Engineers Response

Engineer's Response to Stage 1 Road Safety Audit

The following Engineers comments are in response to items raised within the document provided by Waterman Aspen on behalf of Hayfield Homes titled: Stage 1 Road Safety Audit – SA 3808 September 2022.

Image Nr 4

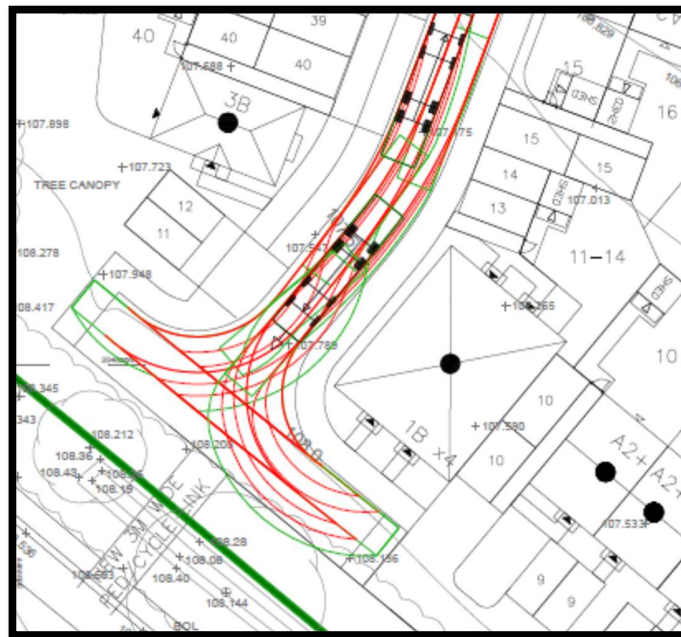
Drawings for vehicle swept paths for a 4-axle refuse vehicle and a fire appliance have been submitted for analysis. An extract of the swept path for a 4-axle refuse vehicle is shown in image number 4 above. The swept path shows how the vehicle will carry out a 180° manoeuvre to leave the turning head in a forward gear. Unfortunately, the swept path shows that the vehicle has to mount the eastern kerb in order to carry out this manoeuvre, with the risk of colliding with a pedestrian walking along the path. This situation may result in injuries.

It is recommended that the design of the turning head is adjusted to ensure that the swept path for a 4 axle refuse vehicle does not mount any kerbs and therefore prevents potential conflicts with pedestrians.

Only the vehicle body overhangs the vehicular crossover to the east. No overhang is proposed on the footway. This is usually considered acceptable for a vehicle with a trip of 1 per week.

Image Nr 5

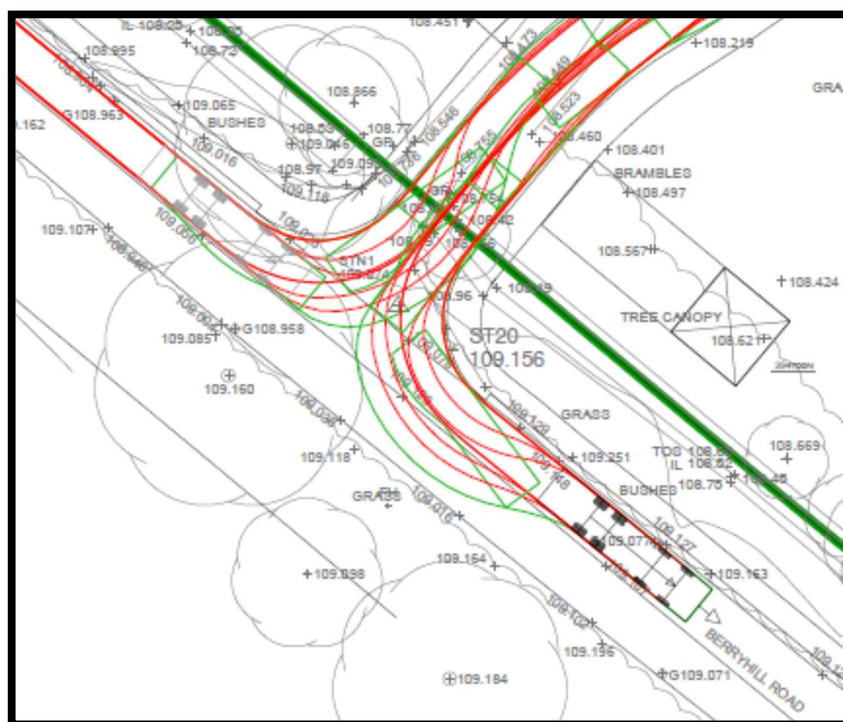
An extract of the swept path for a 4 axle refuse vehicle is shown in image number 5 above. The swept path shows how the vehicle will enter and leave the development Road 1. It also shows that when the vehicle leaves the site, it has to use the opposing lane in order to continue its journey eastwards. As Berry Hill Road is a very well used road, there is the risk of vehicle collisions between the refuse vehicles and other road users. This may result in injuries.

It is recommended that the design of the radii at the junction is amended to ensure that the swept path for the vehicle does not enter the opposing lane.

Proposals are in line with access drawings approved at planning. Sufficient visibility is provided to allow the vehicle to exit the development and also allow oncoming vehicles to see a large vehicle exiting the development, subsequently allowing them to reduce speed and allow the vehicle to existing the development for the 1 trip per week scenario.
